Your Reference: MP 10_0158
Our Reference: NCA/1/2011
Contact: Kale Lafferty
Telephone: 9806 5393
Fax: 9806 5901

23 February 2011

**Major Project 10_0158 – Residential Development – Buildings 7 & 8
61 Mobbs Lane - Epping - Channel 7 Site (Epping Park)**

Figure 8.9 Building Control Diagram

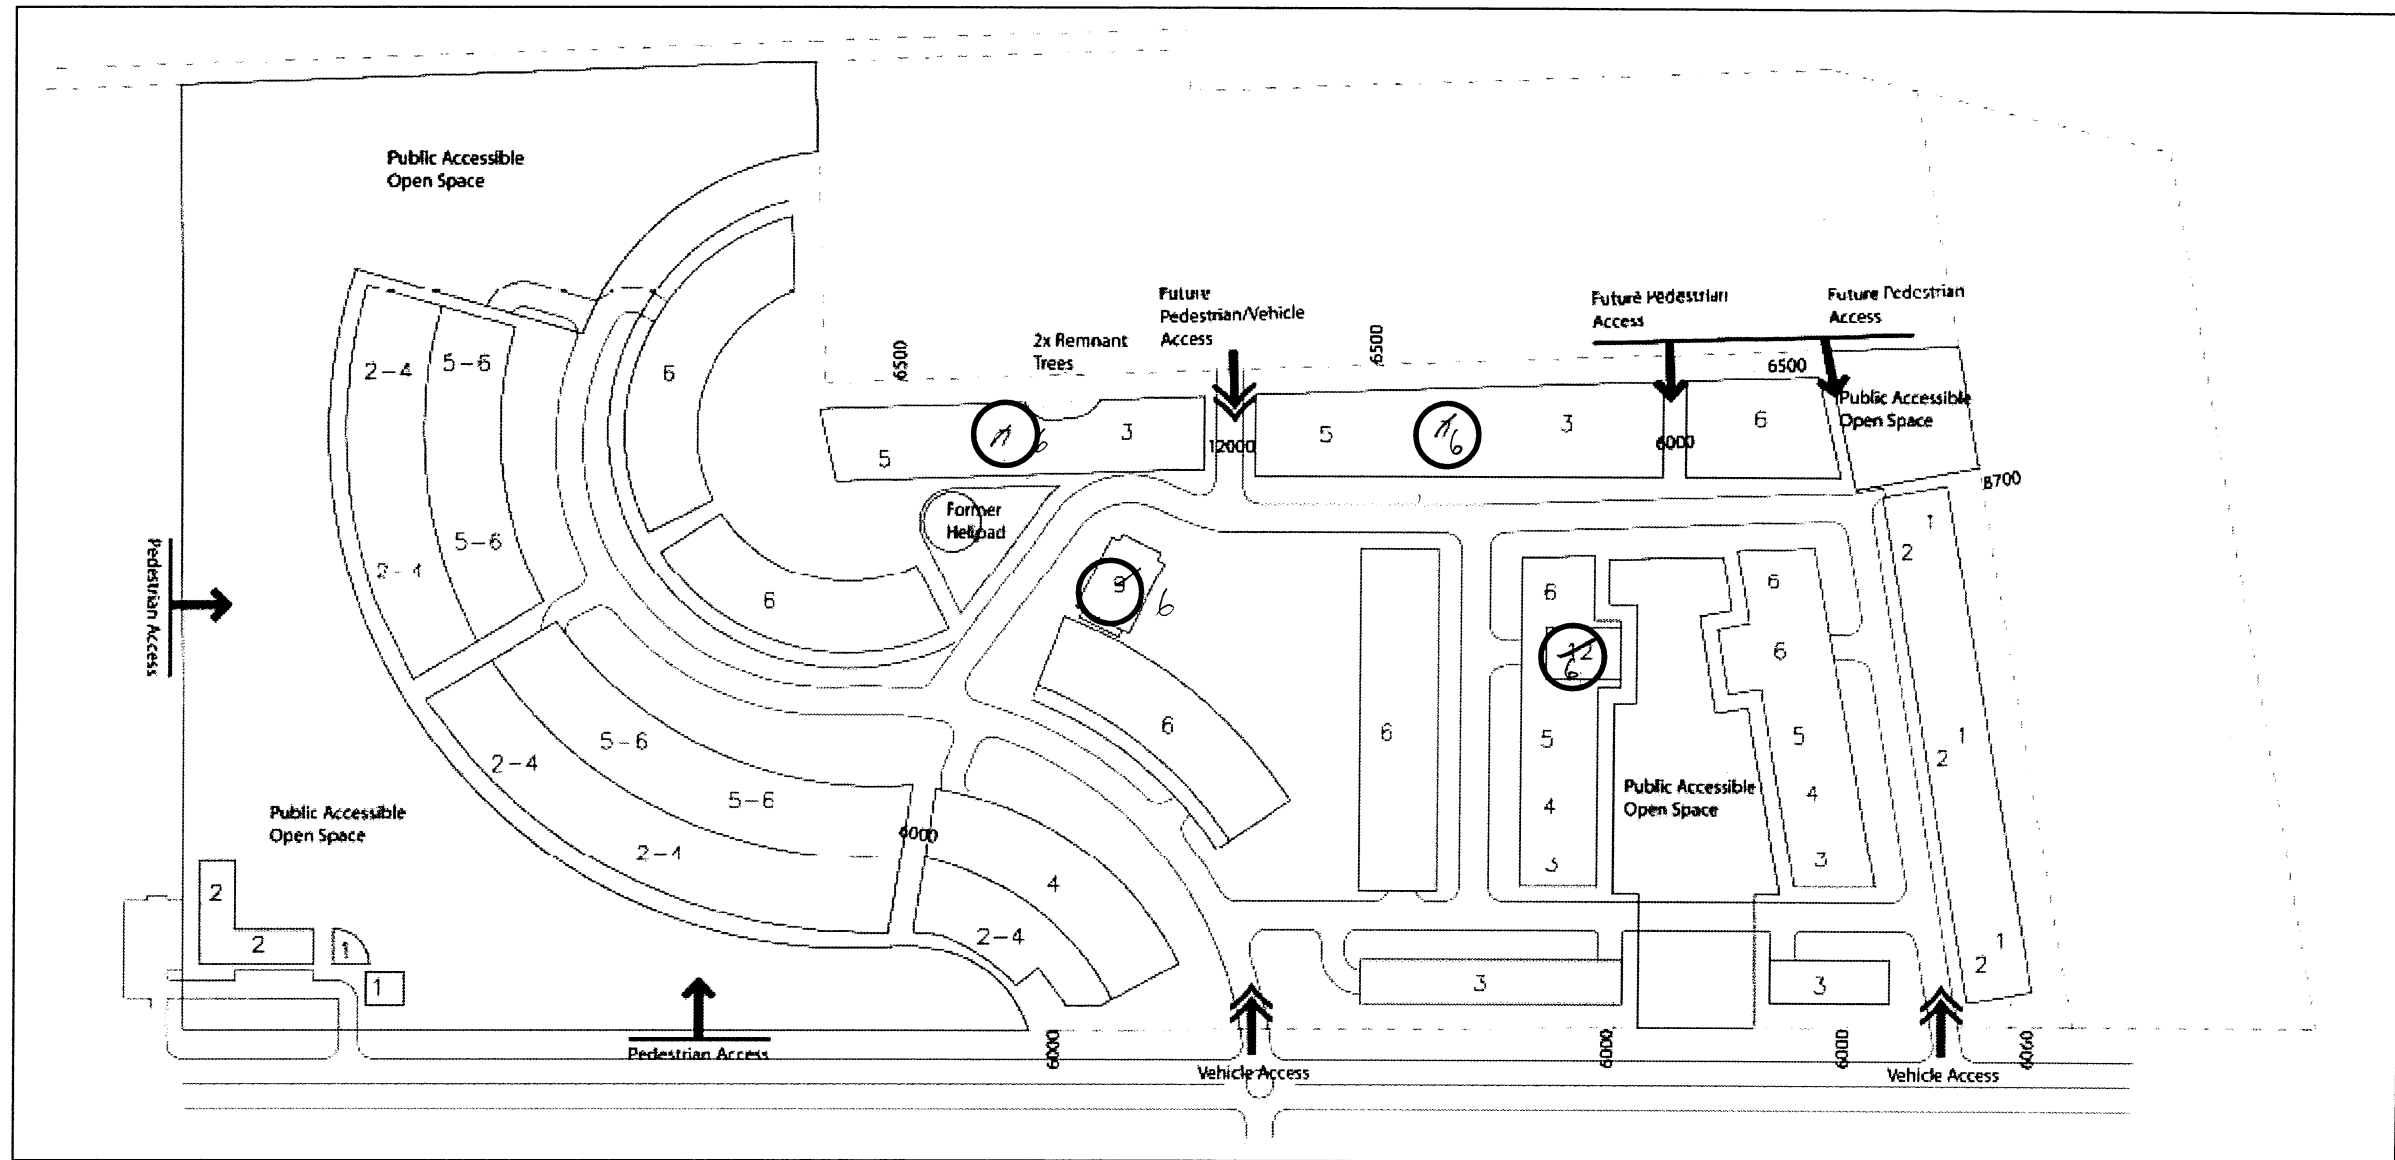
The proposal generally compiles with the controls outlined in Fig 8.9 Building Envelope Control Diagram of the approved Concept Plan (MP 05_0086). However, several issues are raised in relation to SEPP65 Residential Flat Design Code requirements, which are discussed further within this submission.

BUILDING 7 LEVEL G PLAN

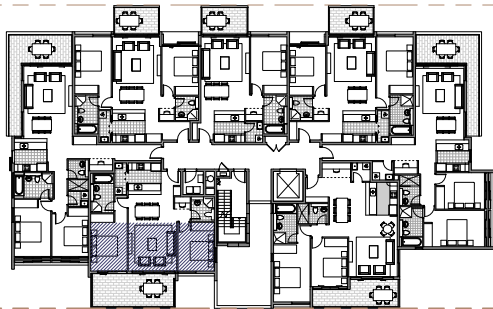
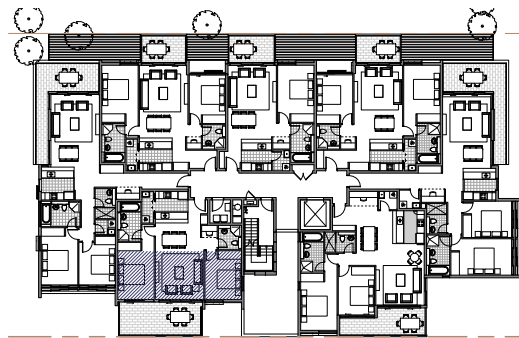
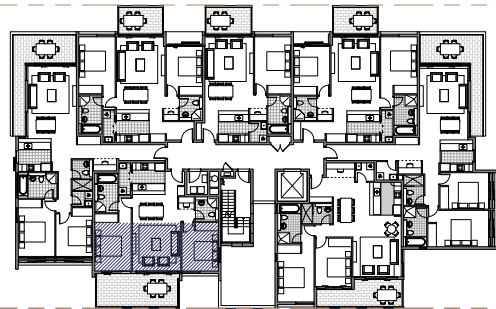
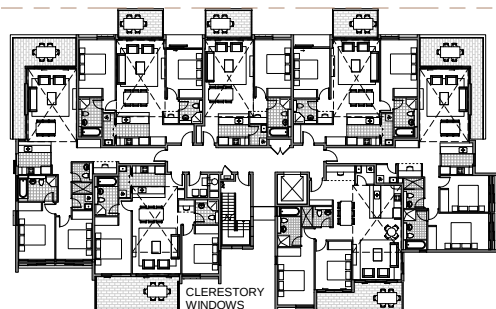
The proposal does not meet key SEPP 65 guidelines for building separation. The proposed separation between buildings 7 and 8 does not meet the following SEPP 65 recommendations:

- 12m is recommended between habitable rooms / balconies (7m is provided); and
- 9m between habitable rooms / balconies and non habitable rooms (7.5m is provided).

The proposal does not meet the SEPP 65 requirement for a minimum of 25% of kitchens to be naturally ventilated. Only the end apartments of Buildings 7 and 8 have kitchens with an external window, giving 26 out of 130 apartments (20%) with naturally ventilated kitchens.

Additionally, many of the apartments have the back of kitchens that are more than 8m from a window. A large number of apartments have the back of kitchens that are over 9 m from an external window.

- Building 8 is separated into two individual buildings with adequate building separation to meet to SEPP 65 requirements;
- a maximum of 10% of apartments are single aspect south facing units (as per SEPP 65);
- there is a minimum separation of 12m between habitable rooms / balconies of buildings 7 and 8 (as per SEPP 65);
- a minimum of 25% of apartments to have kitchens that are naturally ventilated with direct access to an external window (as per SEPP 65);
- the maximum distance between the back of kitchen and an external window is 8m (as per SEPP 65);
- the ground floor apartments along the southern elevation are accessed directly off the street, with individual pedestrian entries activating the streetscape (as per SEPP 65);
- there is a maximum of 8 apartments per building core (as per SEPP 65); and
- there is a maximum building depth of 18m (as per SEPP 65).

BUILDING 8 LEVEL 1 PLAN

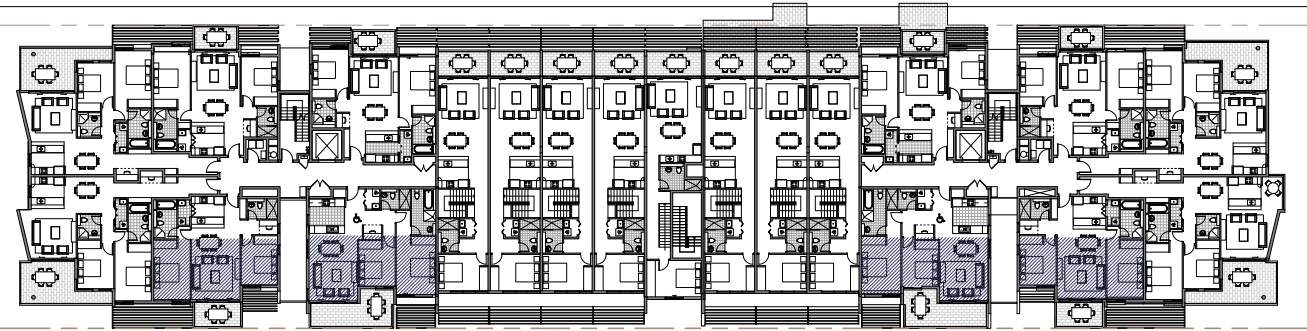
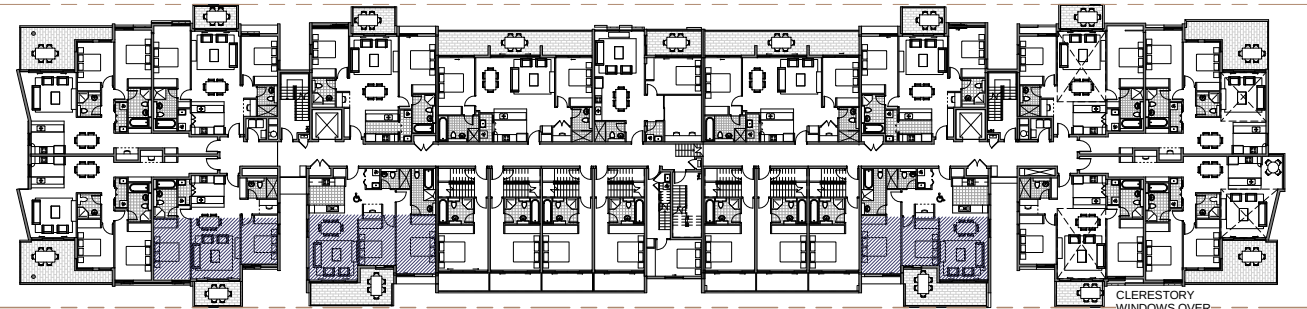
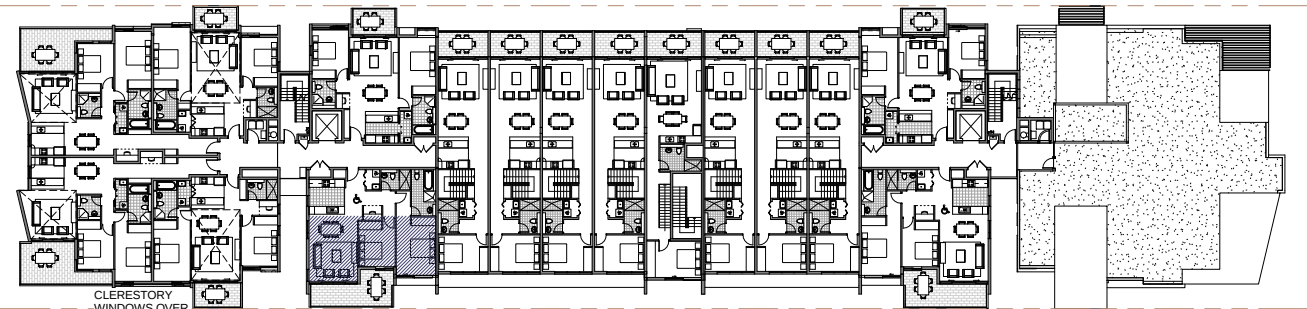
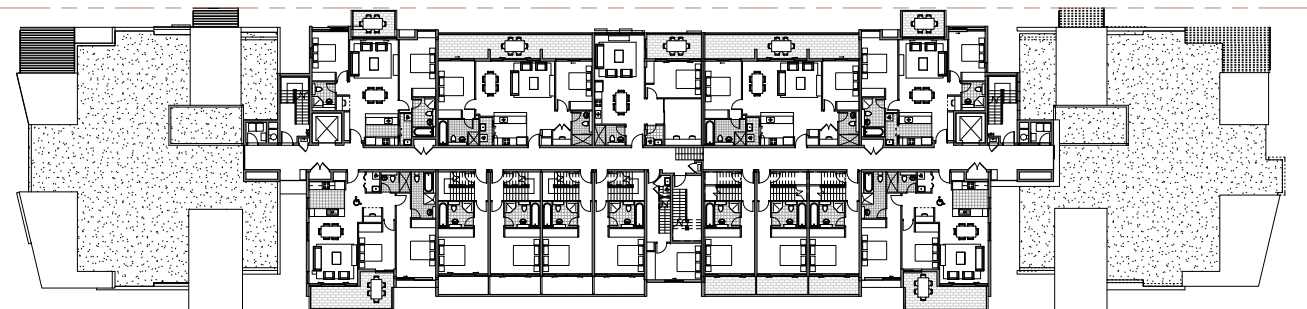
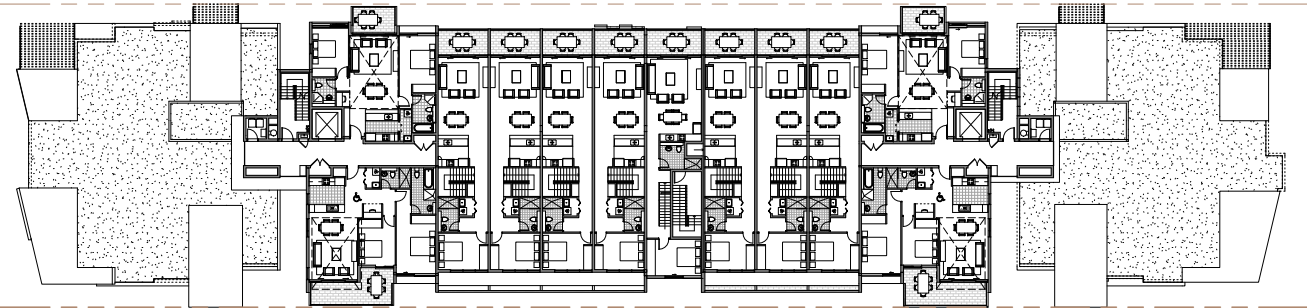
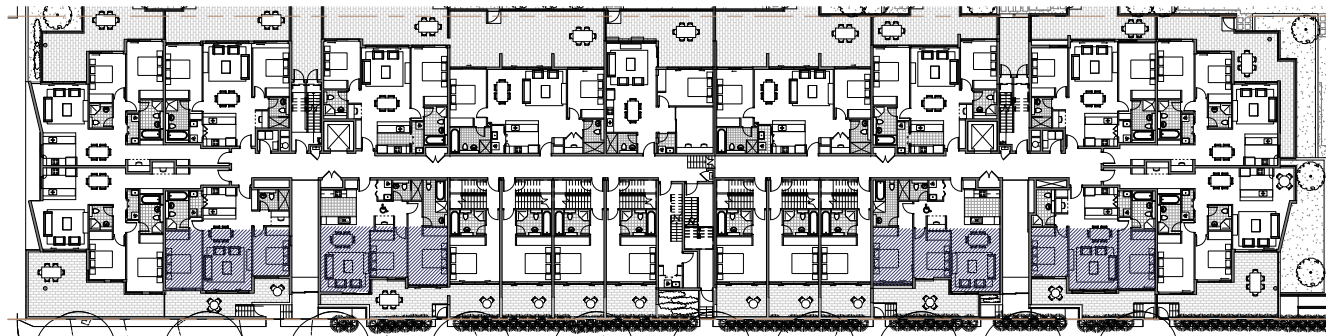
The elevation of Building 8 presents a continuous built edge to 'Road 2' of over 100m. Whilst an attempt has been made to reduce the bulk of this façade through indentation of the plan and articulation of the facade, it still presents a long expanse of built form to the streetscape. This long expanse of building generates residential amenity issues relating to daylight access and natural ventilation, as well as its bulky presentation to the streetscape. Building 8 should be broken into 2 separate buildings to reduce bulk and improve residential amenity. This would address the SEPP 65 residential amenity issues discussed below.

Building 8 has 9 apartments per core, which is above the SEPP 65 recommended maximum of 8. This could be addressed if building 8 is broken down into 2 separate buildings.

The building depth for building 7 and 8 varies but is approximately 20m, which is above the SEPP 65 maximum depth of 18m.
